Subject: FW: Lu/252/21/PL - 6 Selbourne Place, Selbourne Road, Littlehampton, BN17 5NH. Conversion of 8 to 9 bedroom HMO.

Chantelle Bashford
Houses in Multiple Occupation Officer
Private Sector Housing & Public Health Team

Proposed Ground Floor Plan 1:50

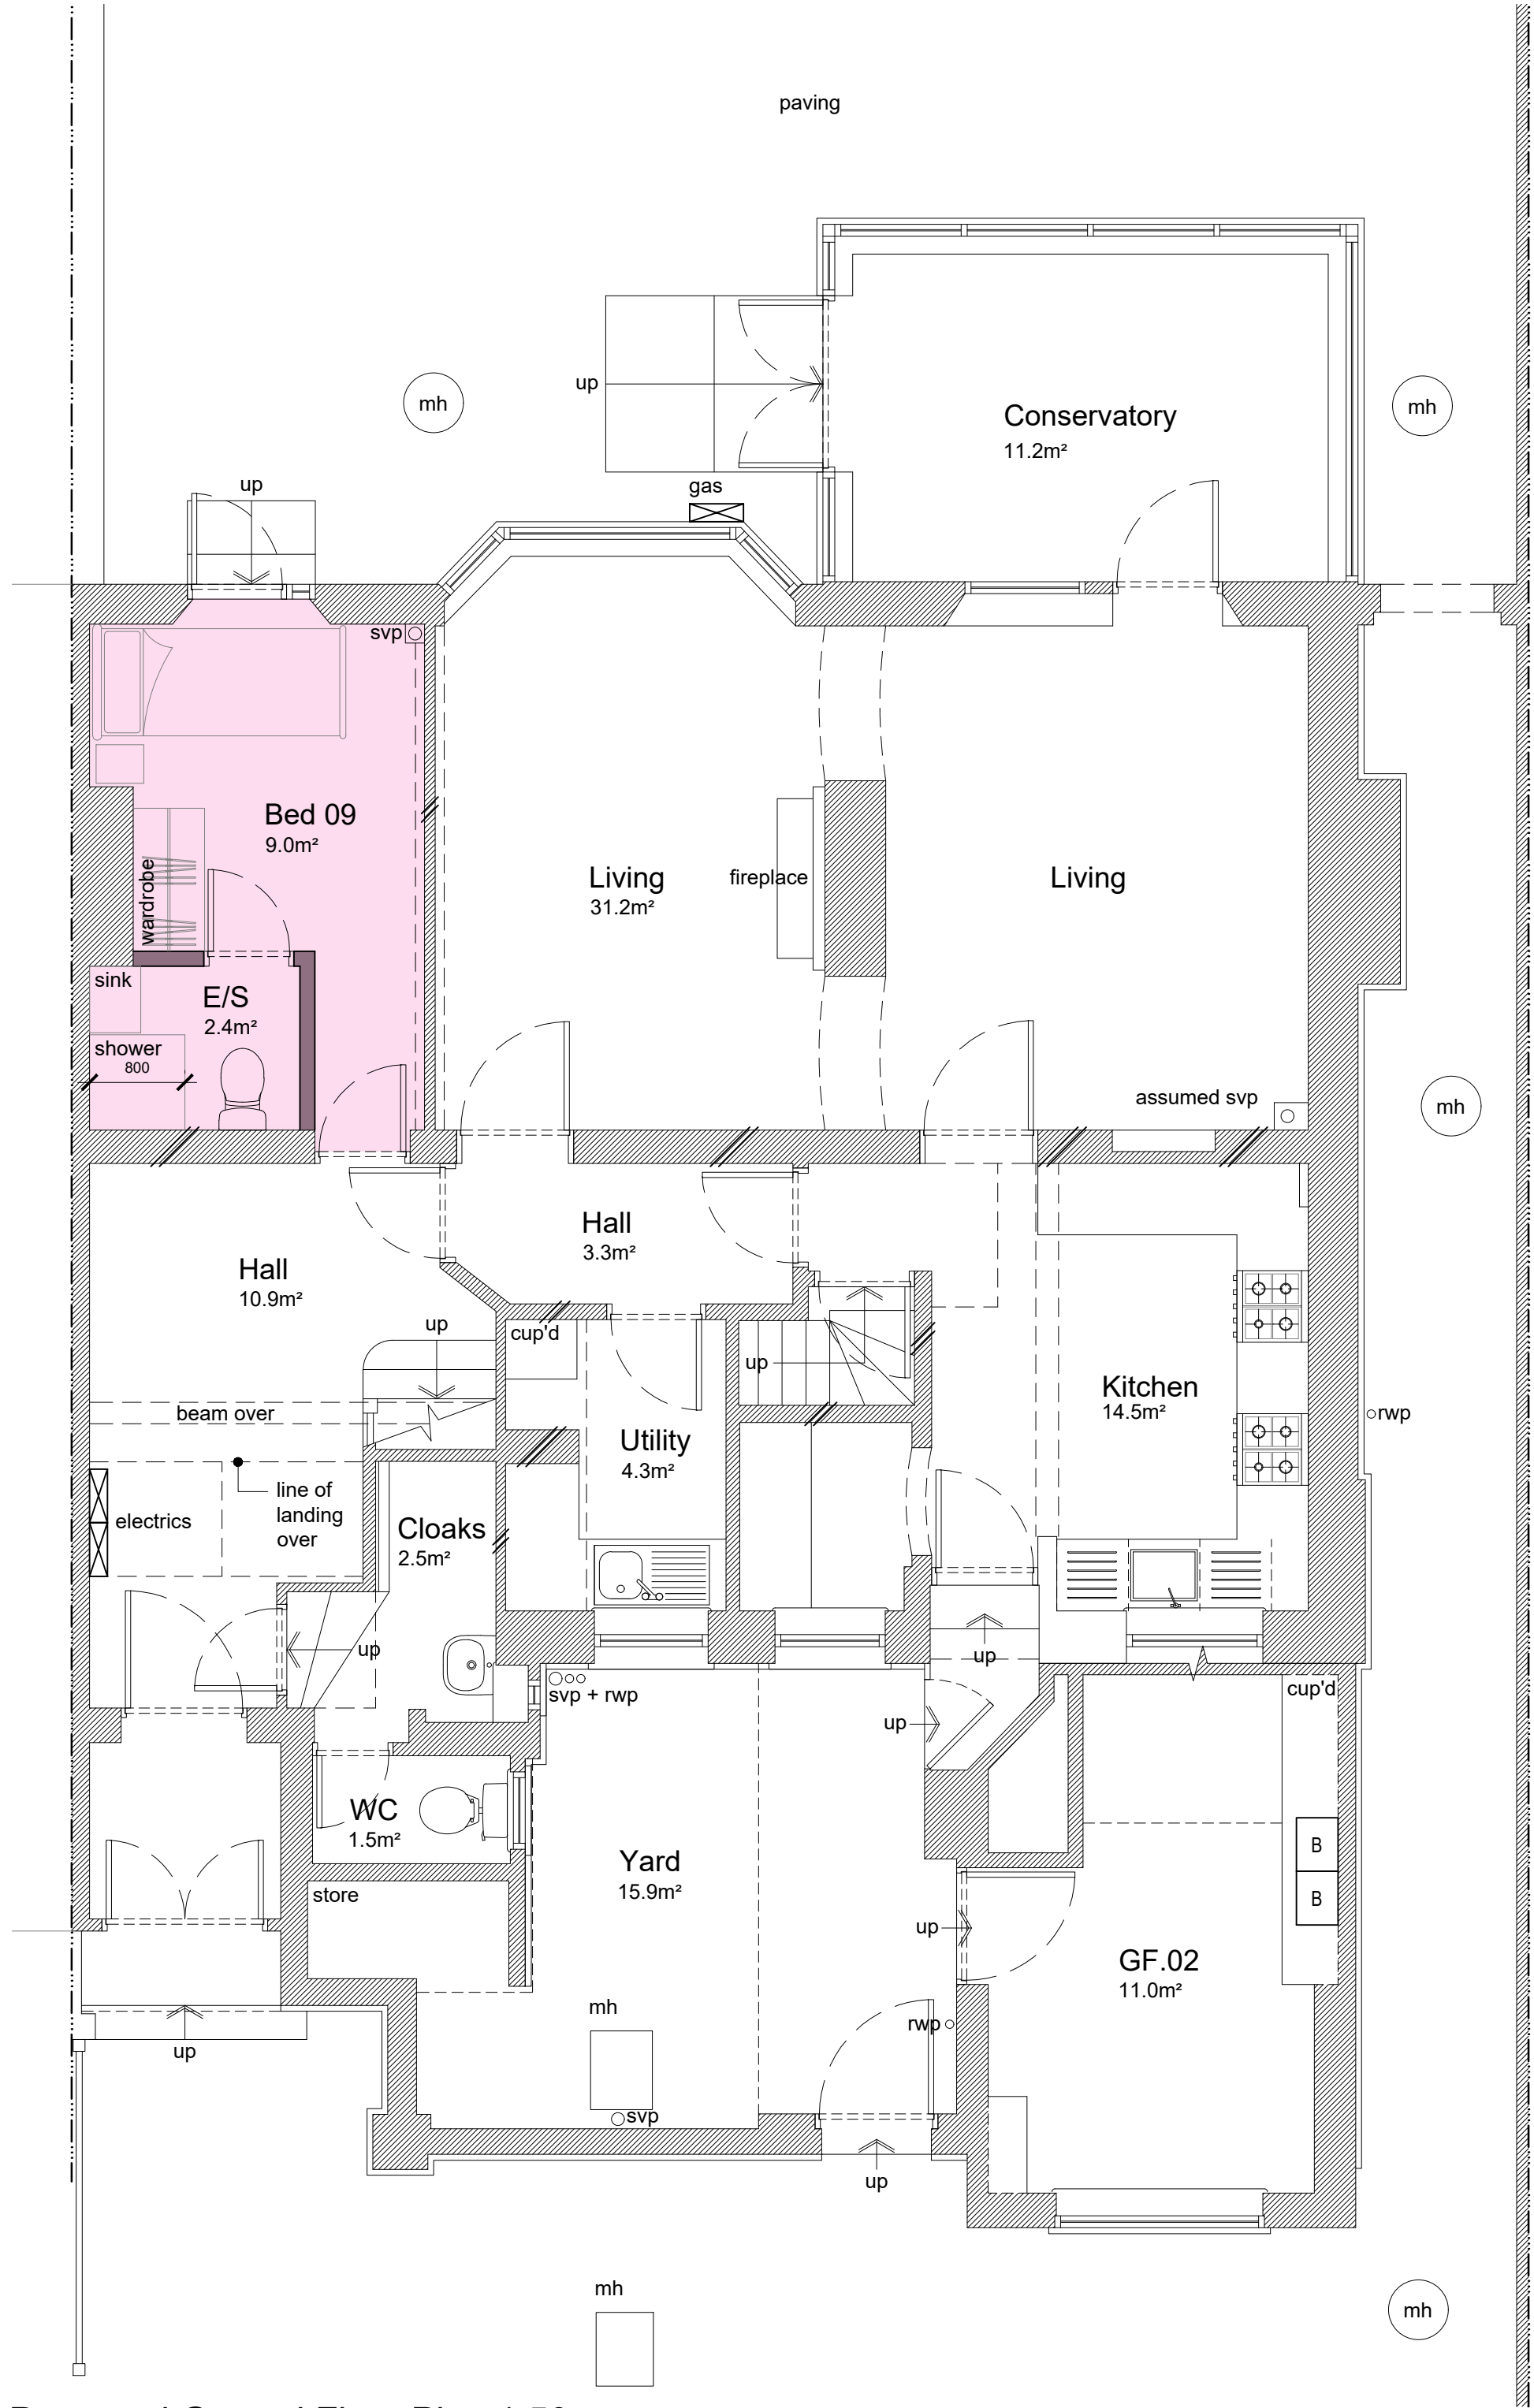
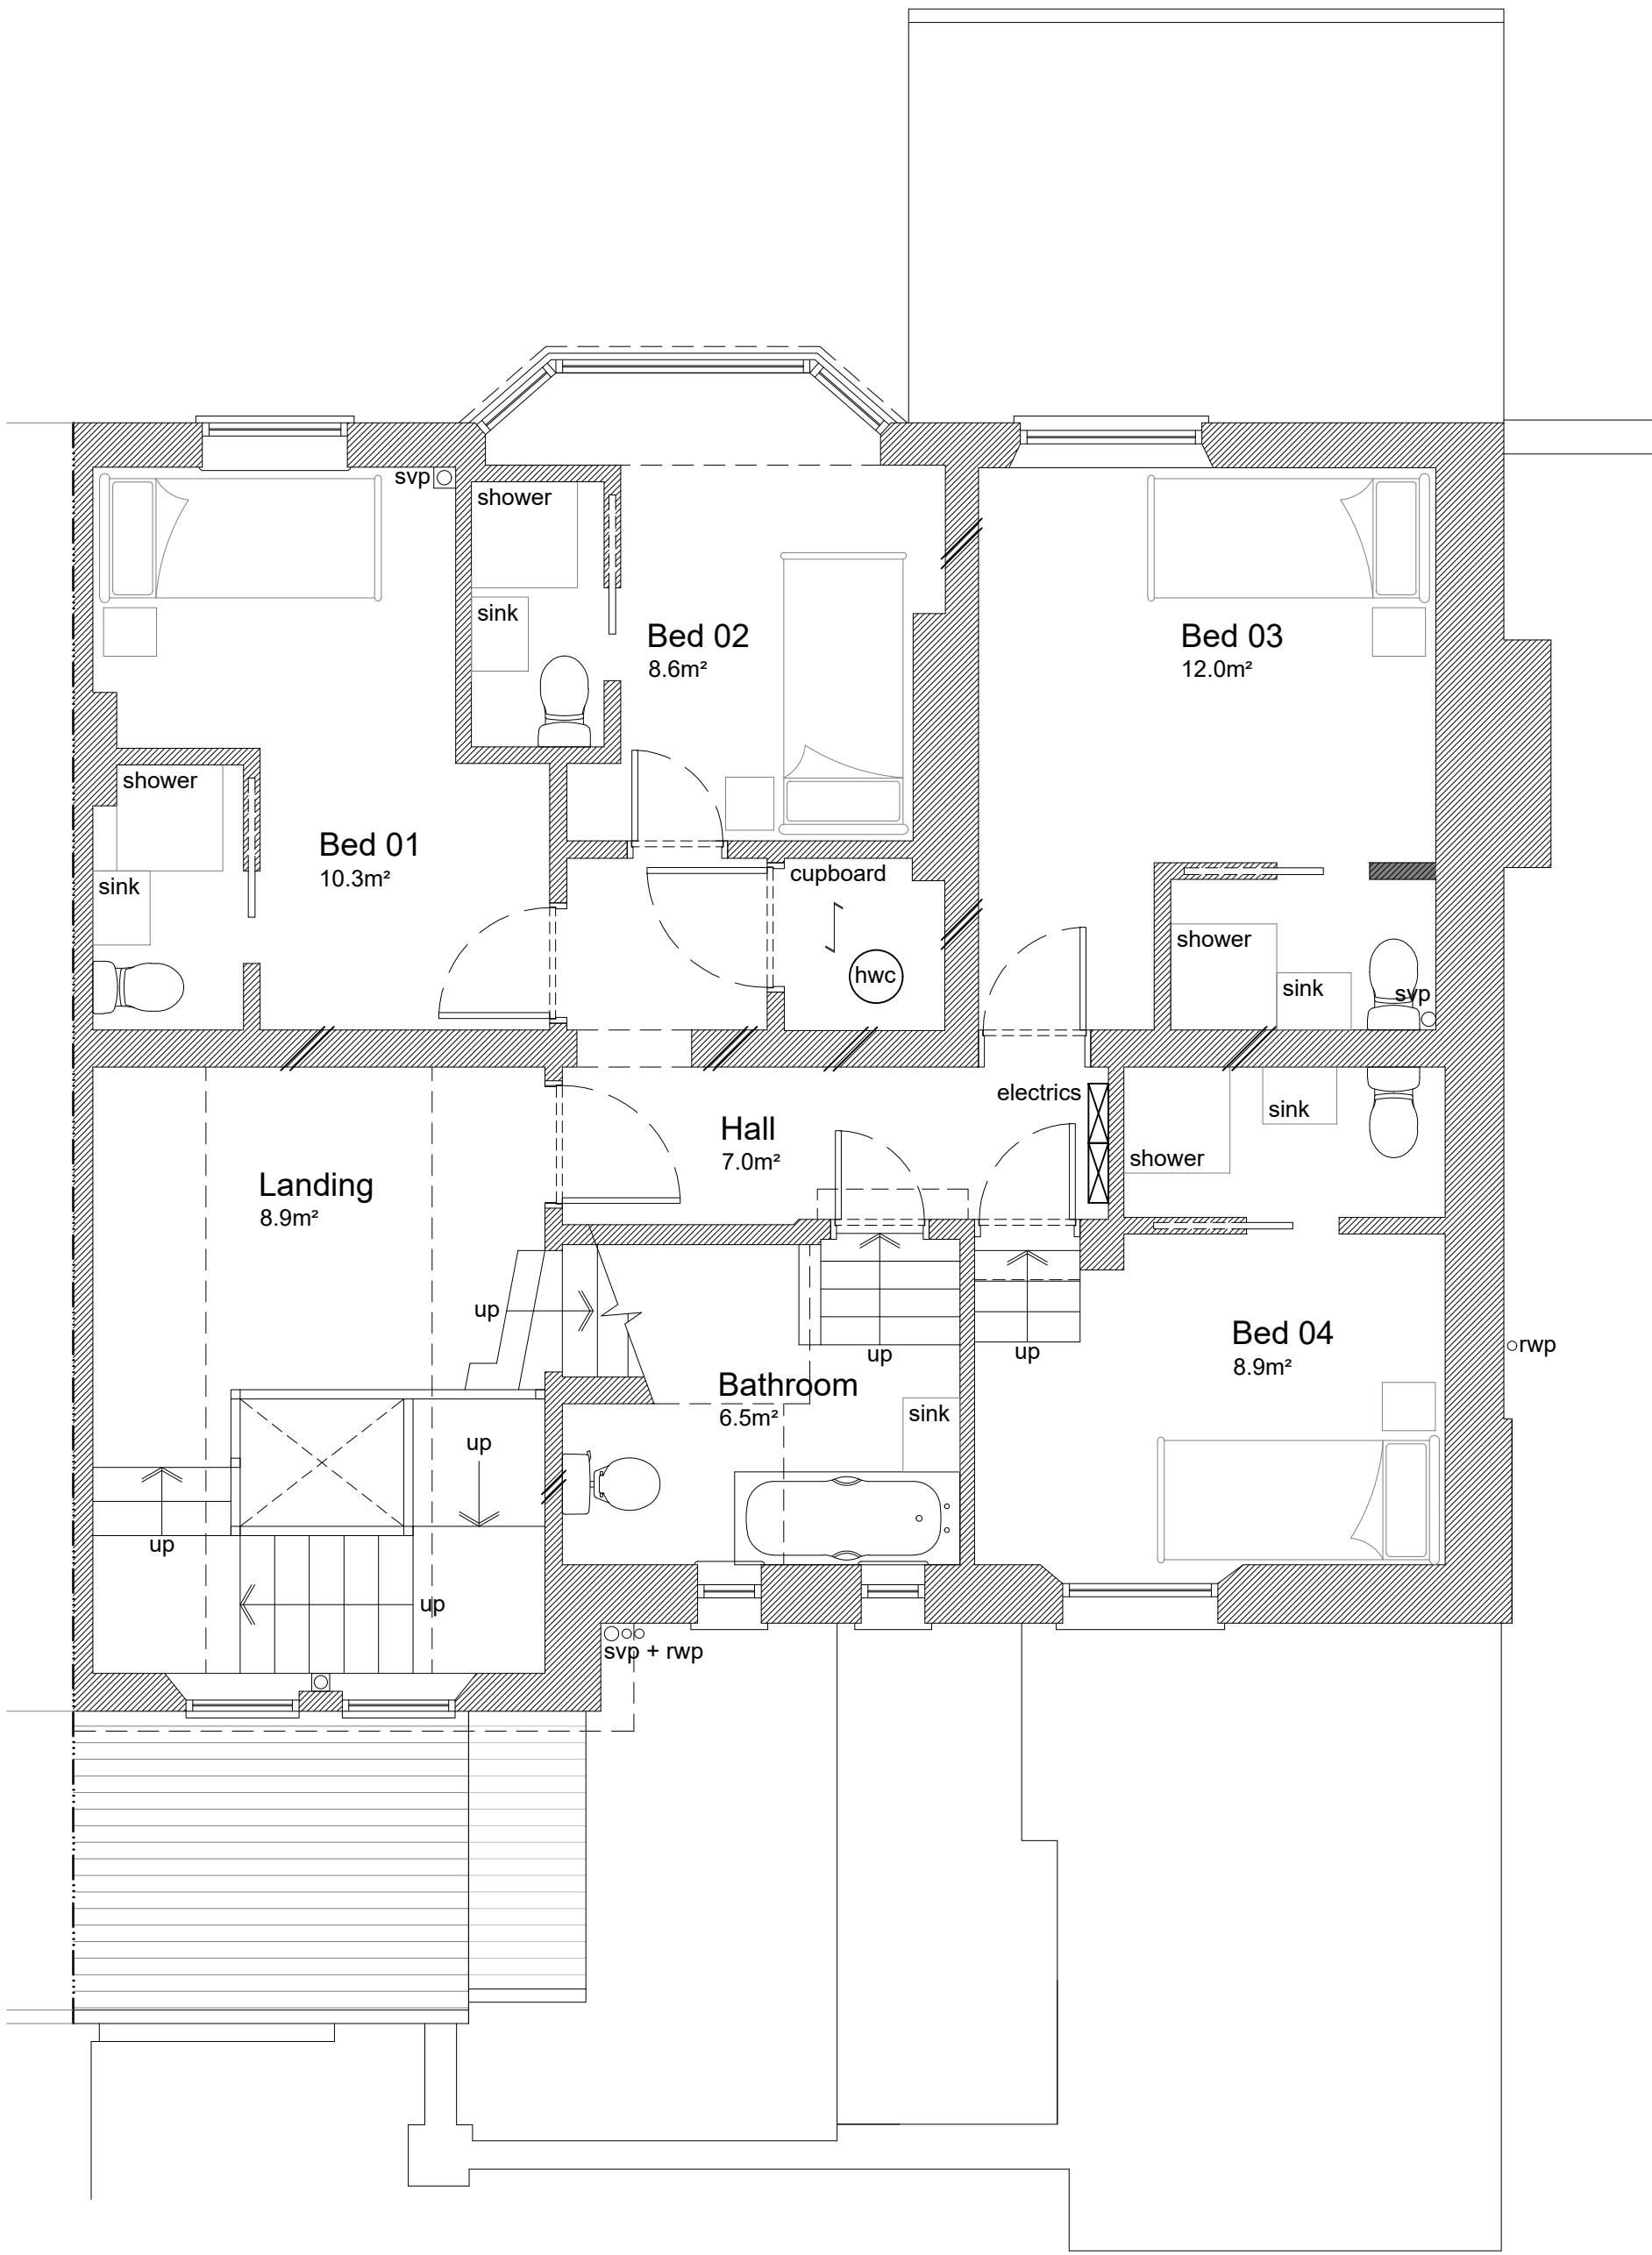
Apologies Anita, one more comment I forgot to include in my initial response; bedroom 9 only appears to have a door in place at the rear. All habitable rooms must have an opening window casement, equivalent to 1/20th of the floor area, to the outside air to provide adequate ventilation. French or patio doors that have no separate openable casements, or where there is no alternative openable casement within the room, are not considered acceptable in bedrooms.

The current licence permits 8 occupants and 8 households across 8 bedrooms, however I note the proposed plans have created an additional 2 bedrooms, suggesting the property may now comprise 10 bedrooms rather than 9. The room to the third floor is currently permitted as a bedroom. Of course, it is possible the owner has decided to no longer use that room as a bedroom; I note it is not labelled 'bed' on the proposed plans as the other bedrooms are.

In addition, condition 45 of the current HMO licence raises concerns regarding the size of the ensuite bathrooms to bedrooms 1, 2 & 6 (bed 6 is labelled as bed 5 on the proposed plans) and actually concludes they are considered inadequate. However, it was taken into account that the property offered 3x communal bath/shower rooms which only one other occupant would be using, therefore it was considered acceptable for the ensuite bathrooms to remain as they were (and not have work completed to them) as long as those occupants would have full access to those communal bathrooms. The proposed plans have not only removed 2 of the 3 communal bathrooms, but some of the bedroom layouts, including walls, have changed. Therefore, it is now possible that other ensuite bathrooms may no longer be considered acceptable, too.
